## **REFUSAL OF PLANNING PERMISSION**

**APPLICATION NO. 2024/0041**

**Proposal** Two and a half storey side extension, loft conversion with flat roof box dormer extension on rear roof plane and new roof lights to front, single storey and one and a half storey front extensions and conversion of 3 out of 4 bays of existing detached garage into a linked annex. (Resubmission) (Different proposal compared with application 2023/0214).

**At** 88 Intake Lane, Pogmoor, Barnsley, S75 2HY

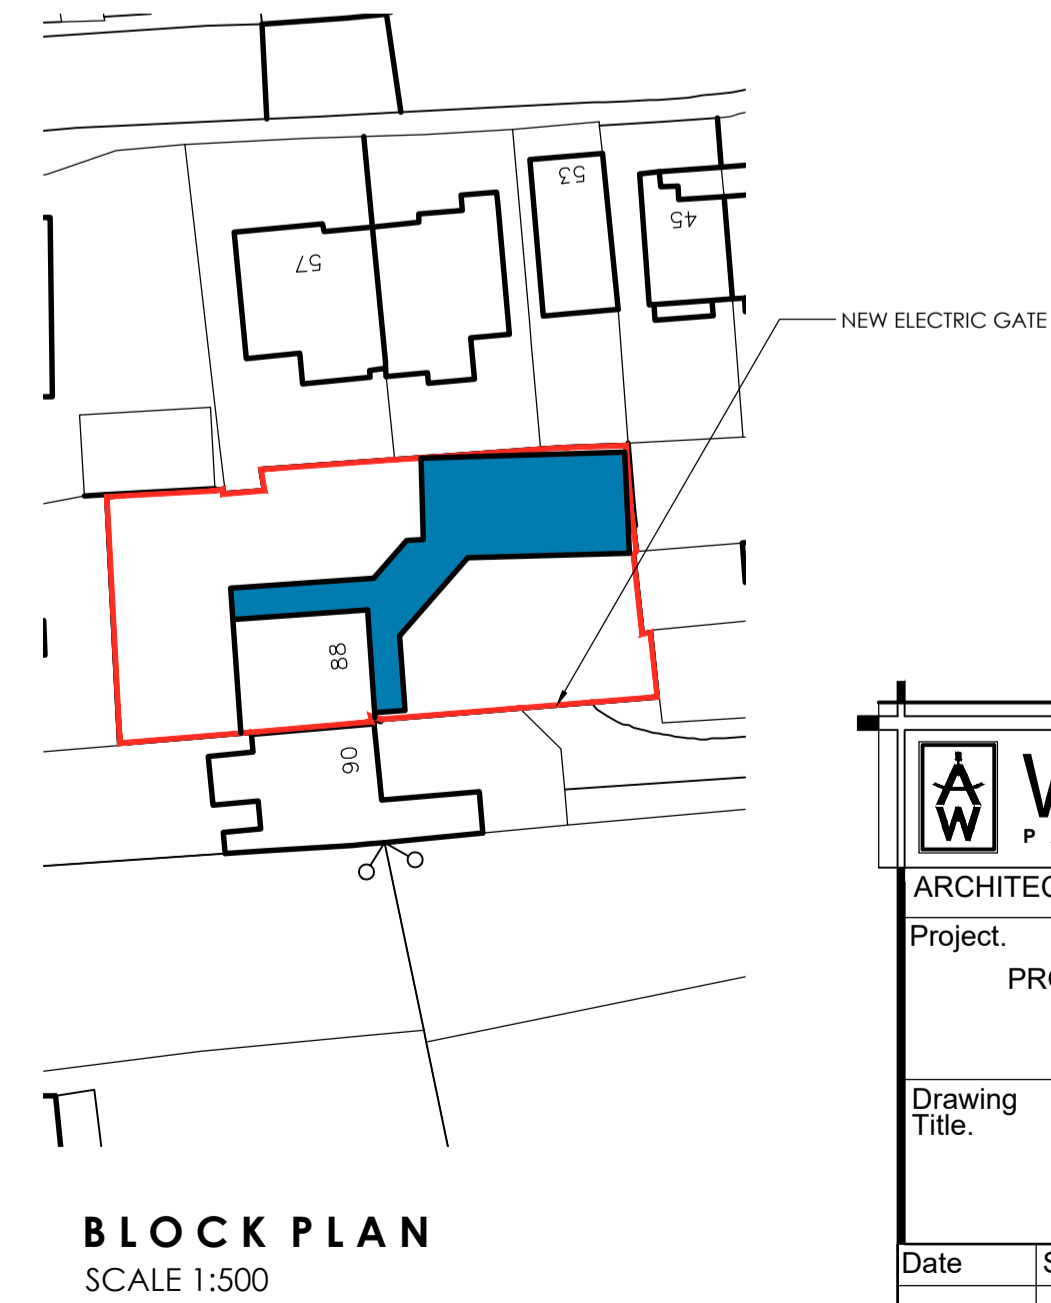
**In the opinion of the Local Planning Authority, the proposal would be contrary to Local Plan Policy D1: High Quality Design and Place Making and the Council's adopted Supplementary Planning Document: House Extensions and Other Domestic Alterations in that the proposed link would not comply with the Council's relevant adopted design criteria. Consequently, the proposal would appear intrusive and overly dominant and is likely to detract from the character of the original dwelling.**
